**EL PASO COUNTY PLANNING AND
 COMMUNITY DEVELOPMENT
 DEPARTMENT**

STORMWATER MANAGEMENT PLAN CHECKLIST

Revised: July 2019

SHEET 10 OF 11  
 JOB NO. 25158.01

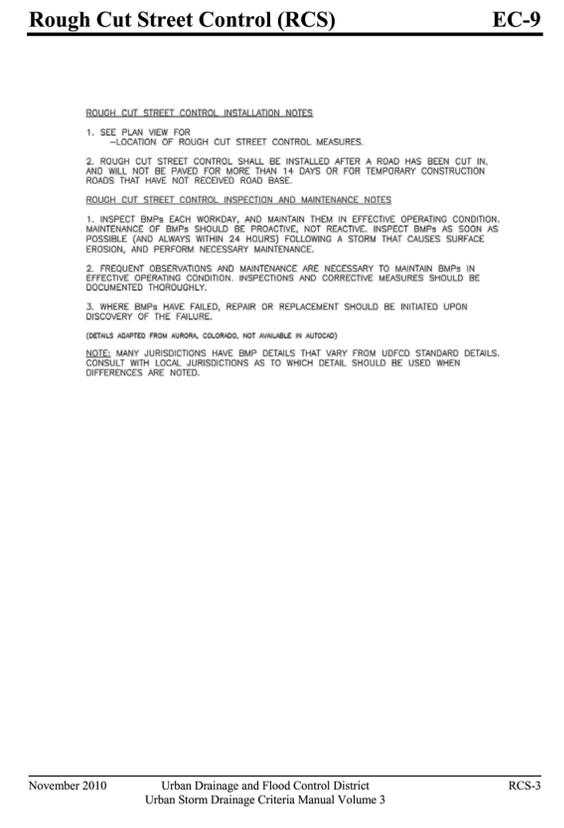
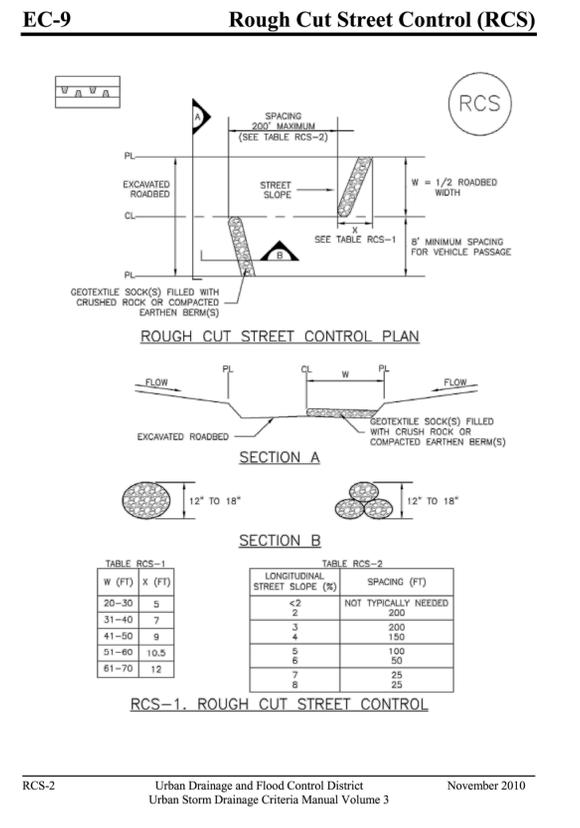
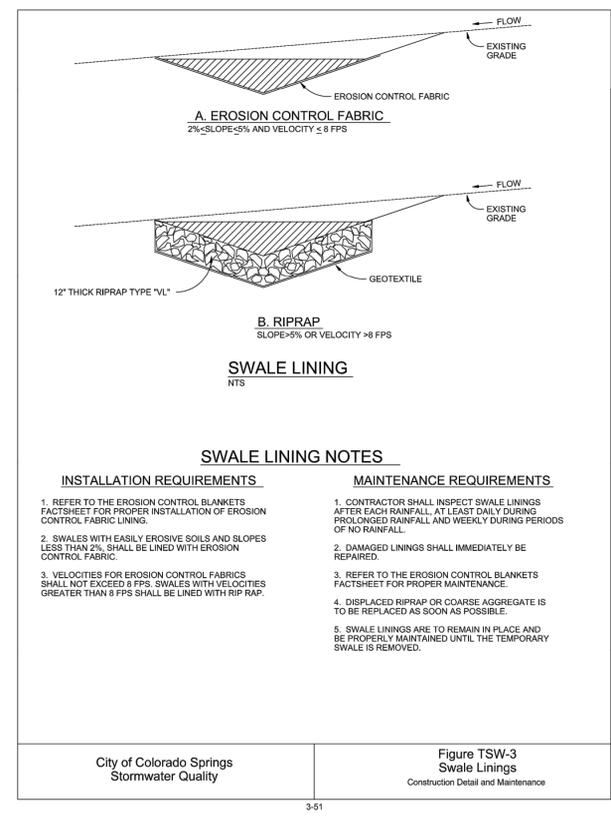
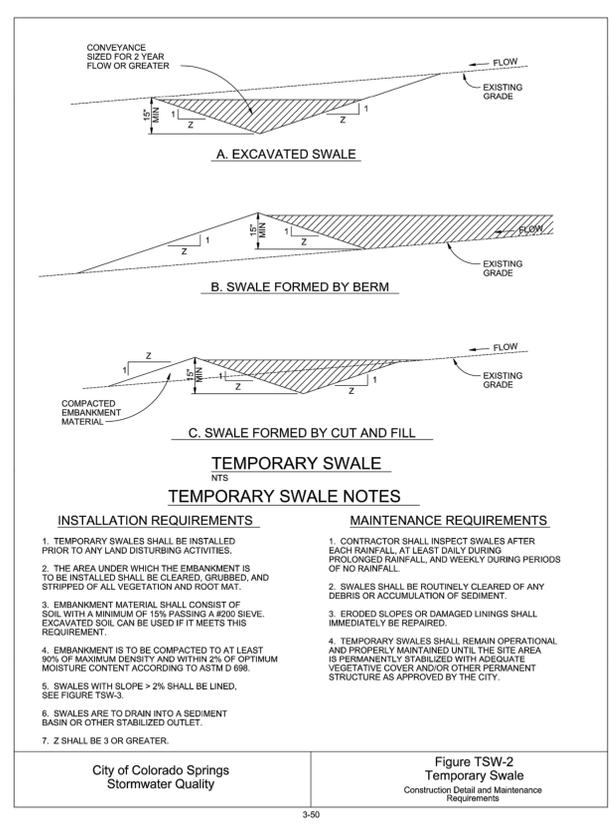
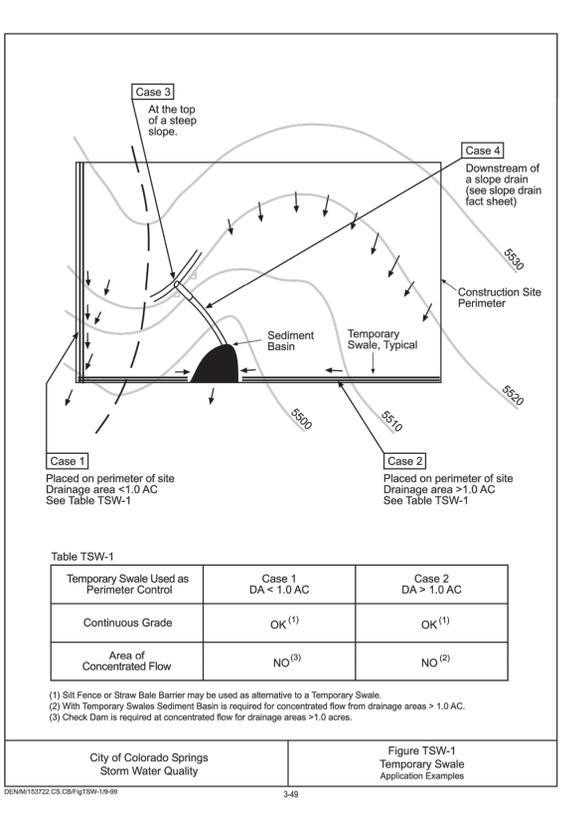
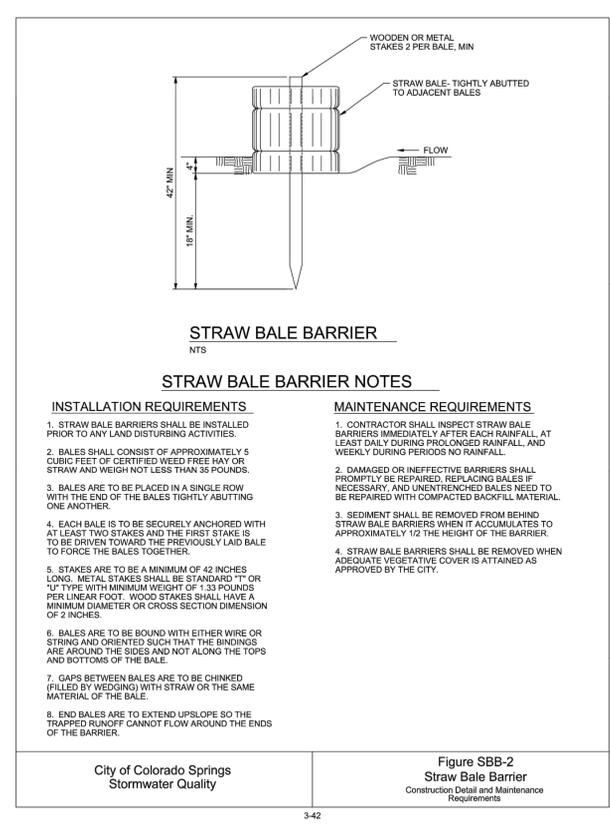
Revised: July 2019		Applicant	PCD
17	SWMP Map to include: See comments on GEC Plan	✓	
17a	construction site boundaries	✓	✓
17b	flow arrows to depict stormwater flow directions	✓	✓
17c	all areas of disturbance	✓	X
17d	areas of cut and fill	✓	✓
17e	areas used for storage of building materials, soils (stockpiles) or wastes	✓	✓
17f	location of any dedicated asphalt / concrete batch plants	✓	✓
17g	location of all structural control measures	✓	✓
17h	location of all non-structural control measures	✓	✓
17i	springs, streams, wetlands and other surface waters, including areas that require maintenance of pre-existing vegetation within 50 feet of a receiving water	✓	✓
18	Narrative description of all structural control measures to be used. Modifications to EPC standard control measures must meet or exceed County-approved details.	✓	✓
19	Description of all non-structural control measures to be used including seeding, mulching, protection of existing vegetation, site watering, sod placement, etc.	✓	✓
